WEST SUSSEX COUNTY COUNCIL CONSULTATION

TO:	Arun District Council FAO: Michael Eastham
FROM:	WSCC - Highway Authority: Tim Townsend
DATE:	29 October 2020
LOCATION:	Land south of Ford Lane East of North End Road Yapton BN18 0DS
SUBJECT:	Y/105/20/DOC Approval of details reserved by condition imposed under Y/80/16/OUT relating to condition 10- Construction Method Statement. More information received.
DATE OF SITE VISIT:	19 October 2020
RECOMMENDATION:	More Information Required
S106 CONTRIBUTION TOTAL:	n/a / £ See below for breakdown.

This is the second WSCC County Highway Authority (CHA) response to the above planning application for approval of details reserved by condition imposed under Y/80/16/OUT relating to condition 10 - Construction Method Statement (CMP). Previous CHA comments were made in response dated 19th October 2020.

LARGE TIPPER: LEFT TURN IN

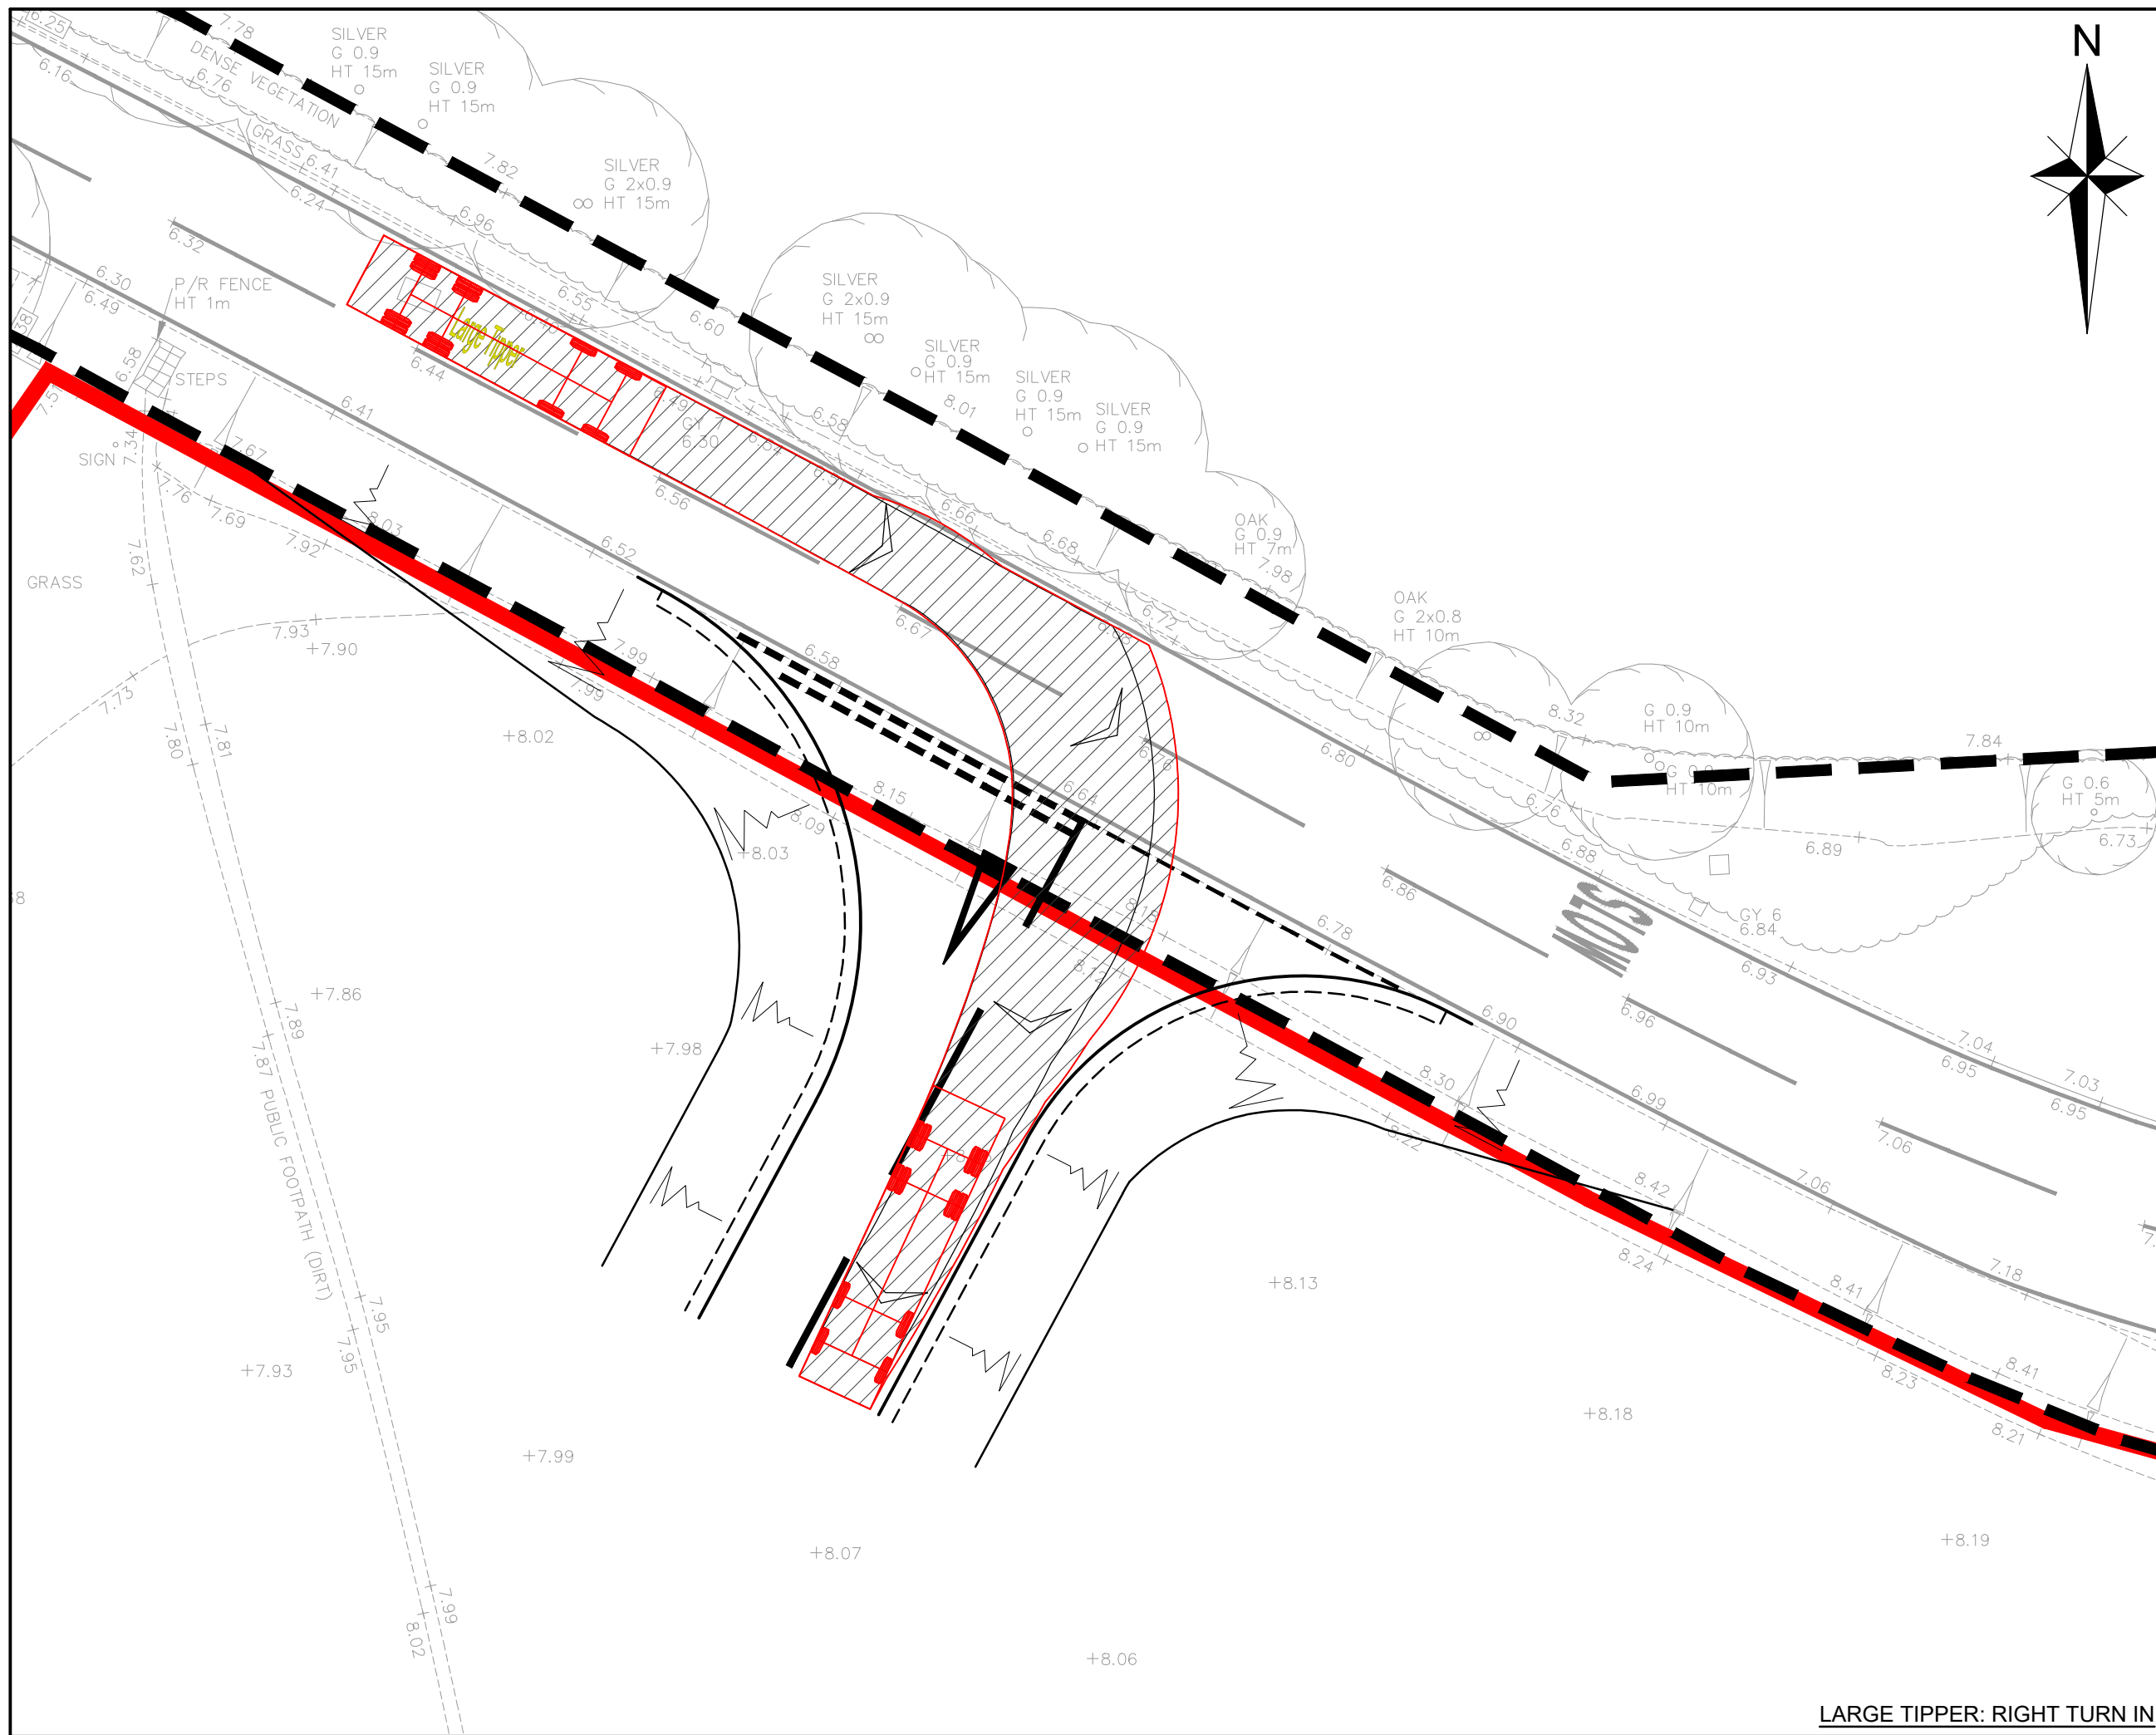
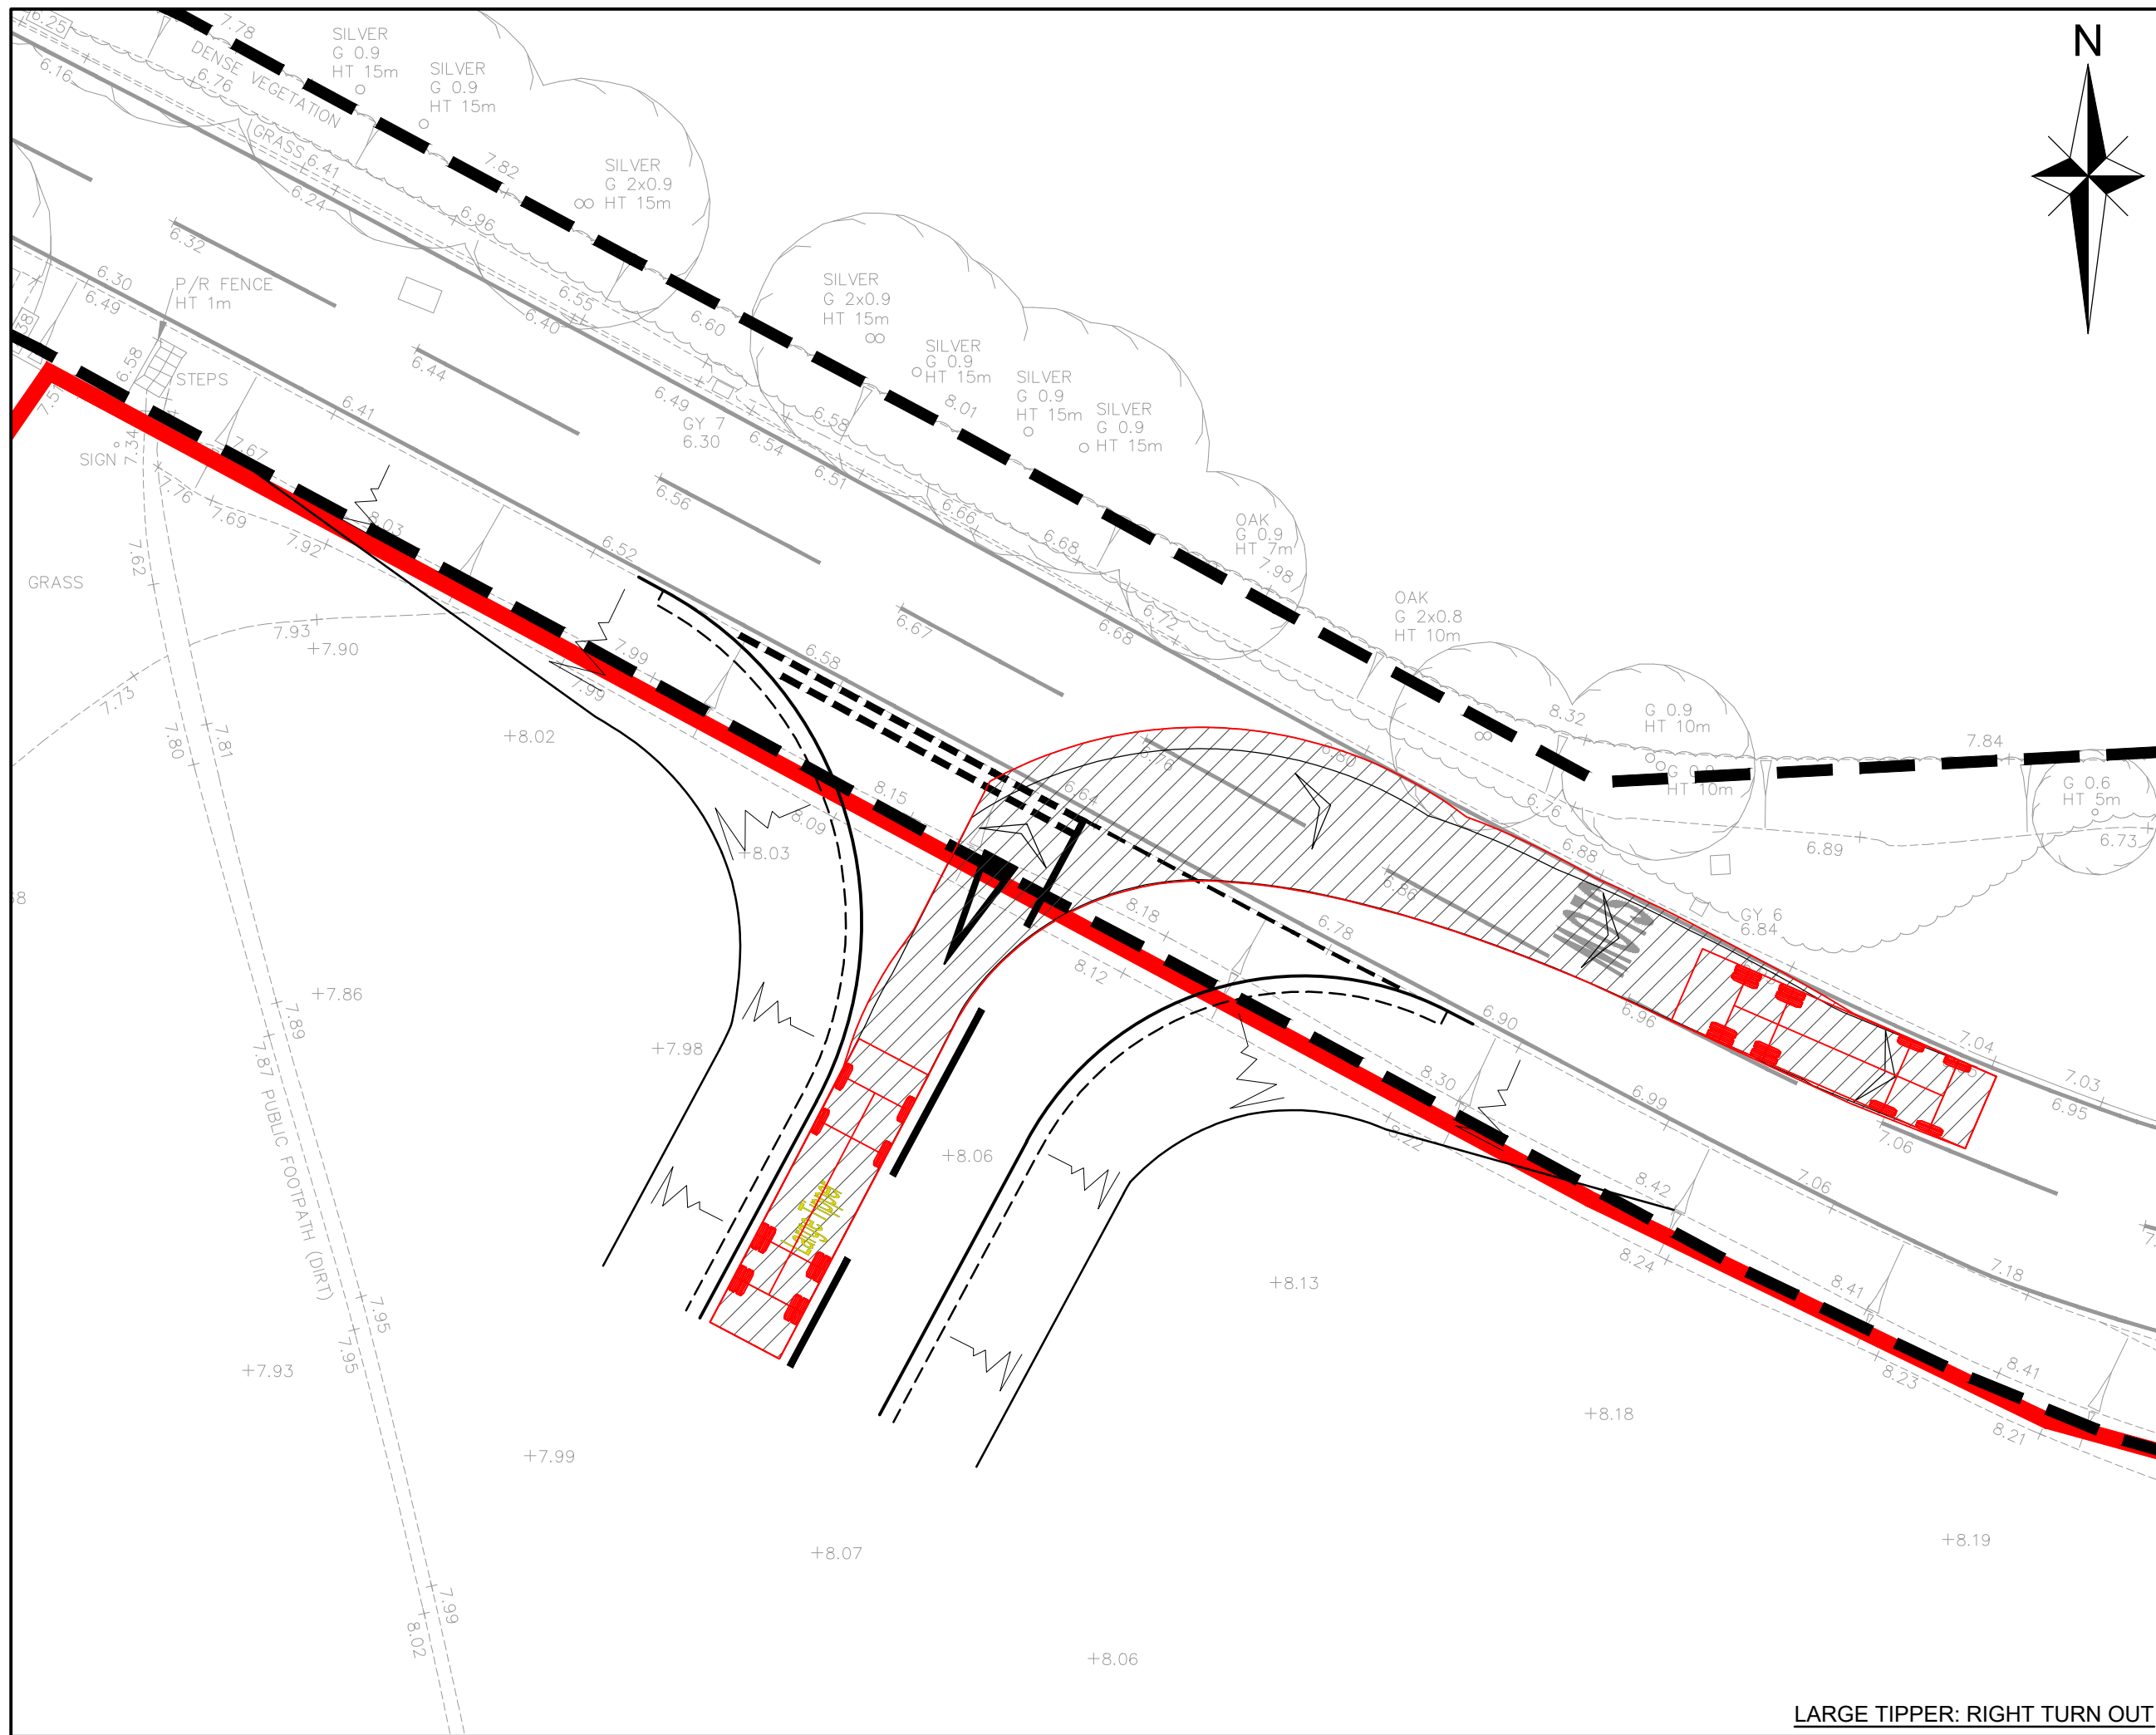
by the CHA. The designer should provide information to satisfy the recommendation contained in the Audit. If the recommendation cannot be achieved, then the designer should provide an alternative solution including information such as additional swept path diagrams, frequency of trips using the access and any other controls relating to the use of the access that would be implemented throughout the construction period.
